The Local Highway Authority advises the following reason for refusal:

The Local Highway Authority (LHA) are in receipt of an application for the proposed industrial unit 59.5msq behind existing industrial unit of 169msq at Central Garage, Warwick Street, Longridge.

The LHA are aware that the site is located off Warwick Street, an unclassified road subject to a 20mph speed limit. The LHA has reviewed the proposed site plan drawing number 1538/02 Revision A, and is aware that the site will utilise an amended access which also serves the existing commercial unit. The removal of the gates and a section of wall will increase the width of the access to 6.7m wide.

Swept Path of Light Van Arriving
(4 Point Manoeuvre)
Scale 1 / 250 @ A3

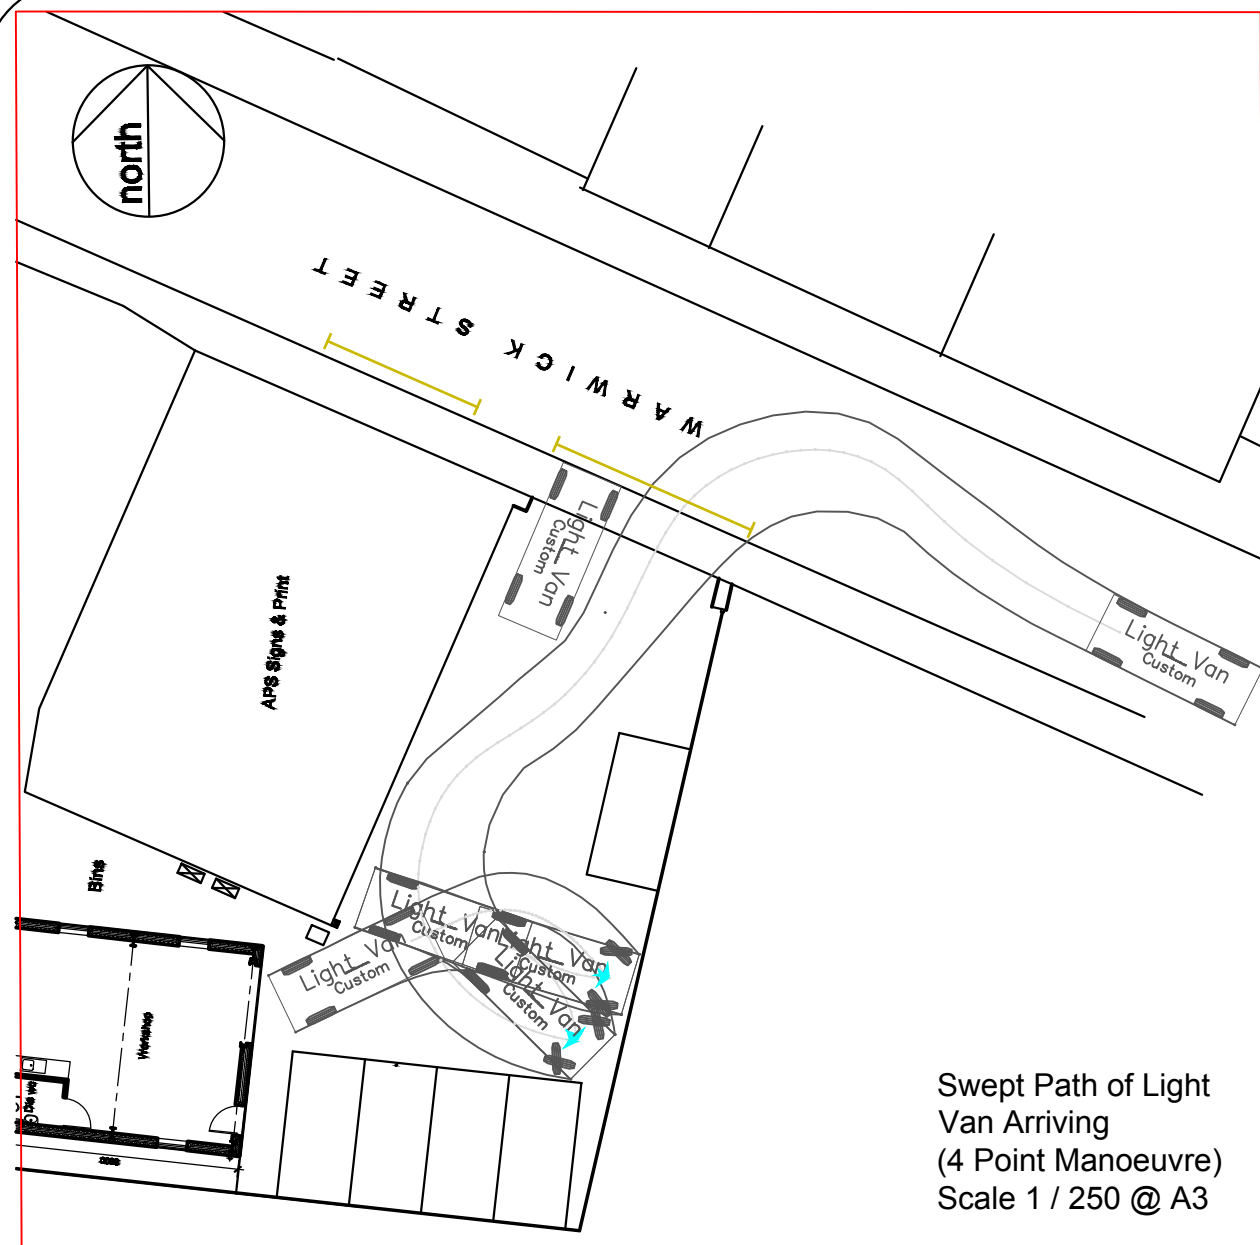
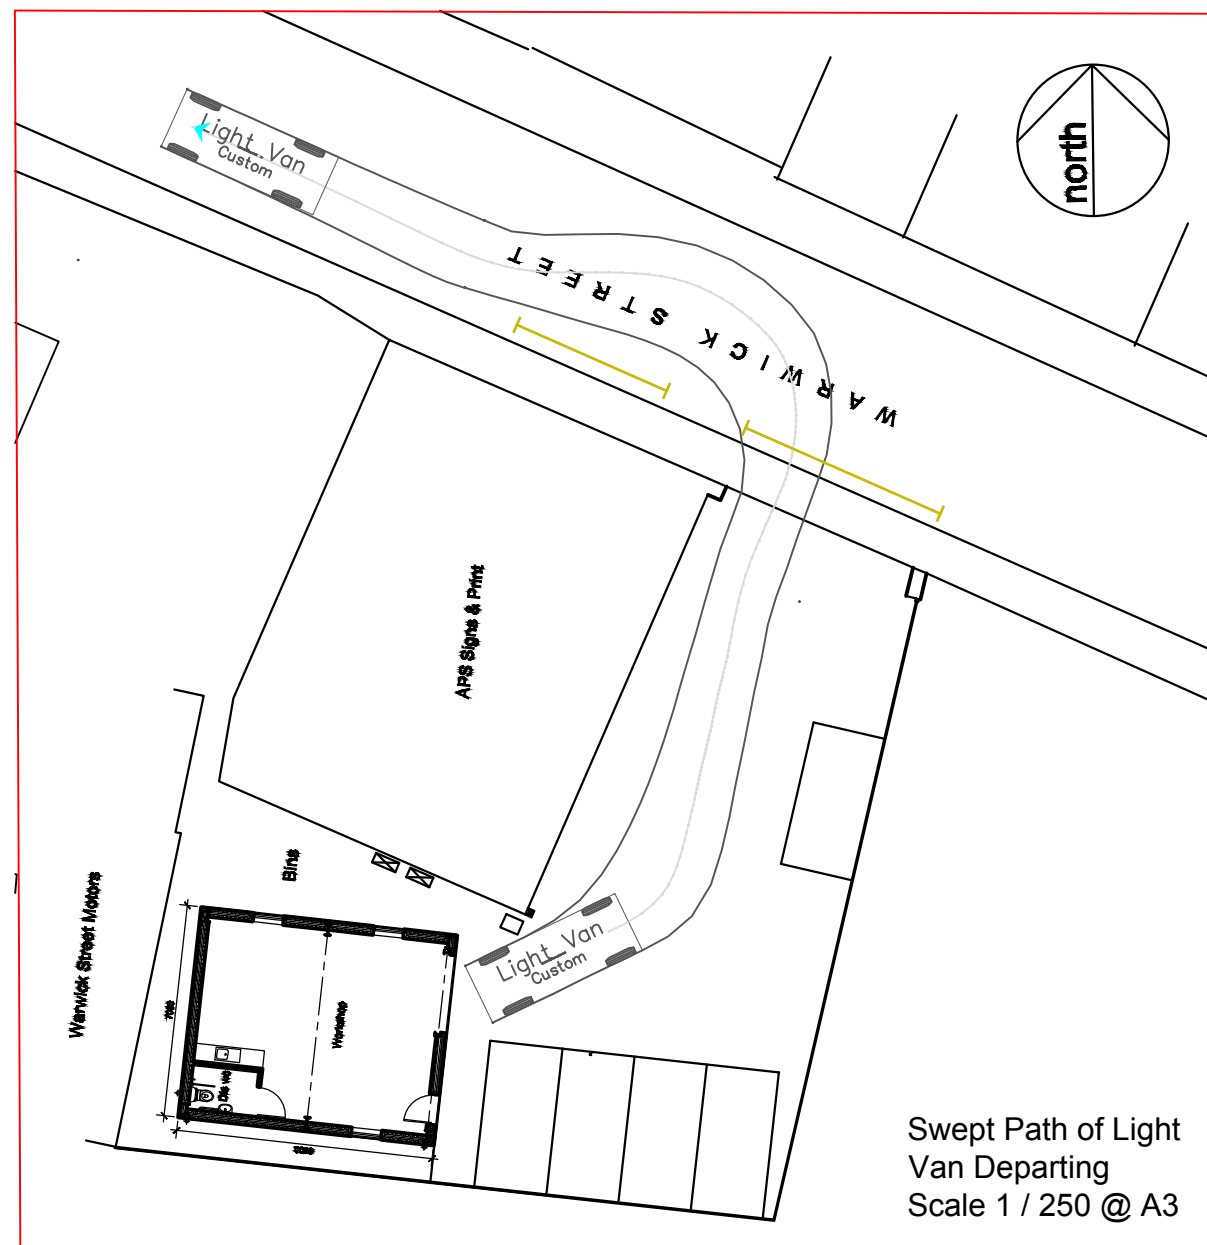
The LHA are of the opinion that whilst drawing 240901/01 shows a lights goods vehicle accessing the site, turning within and exiting the site in a forward gear, the LHA do have concerns over the practicality of such vehicles turning in practice given the limited space available.

The applicant has stated that deliveries also take place in large vans therefore it is the LHAs opinion that this is represented in the Swept Path of Medium Goods Vehicles Turning shown within drawing 240901/01. The applicant has also provided further clarification on the manoeuvring of such vehicles in order to serve the site 'drawing 240901/01 shows a medium goods vehicle reversing into the site and exiting the site in a forward gear'. Vehicle turning within the site for a medium goods vehicle is not possible, the drawing also does not represent the true street scene. To undertake such a manoeuvre would require that no vehicle parking takes place adjacent to the access and opposite. A site visit and Google Street View shows that this is not the case on Warwick Street. Whilst the applicant has very recently applied for a H Bar, a recent site visit and Google Street View history indicate that the H Bar markings already present on Warwick Street are not fully self-enforcing and overhang parking does take place. This also does not take into account parking on the opposite side of Warwick Street. As can be seen from drawing 240901/01 even with a H Bar marking, the vehicle turning would still cross over sections which cannot be protected.

This is done daily, this is how I park, I agree that the Vehicle turning plan is slightly incorrect as it states a 4 point turn, we do this in 3, and can supply a drone video to show if you wish.
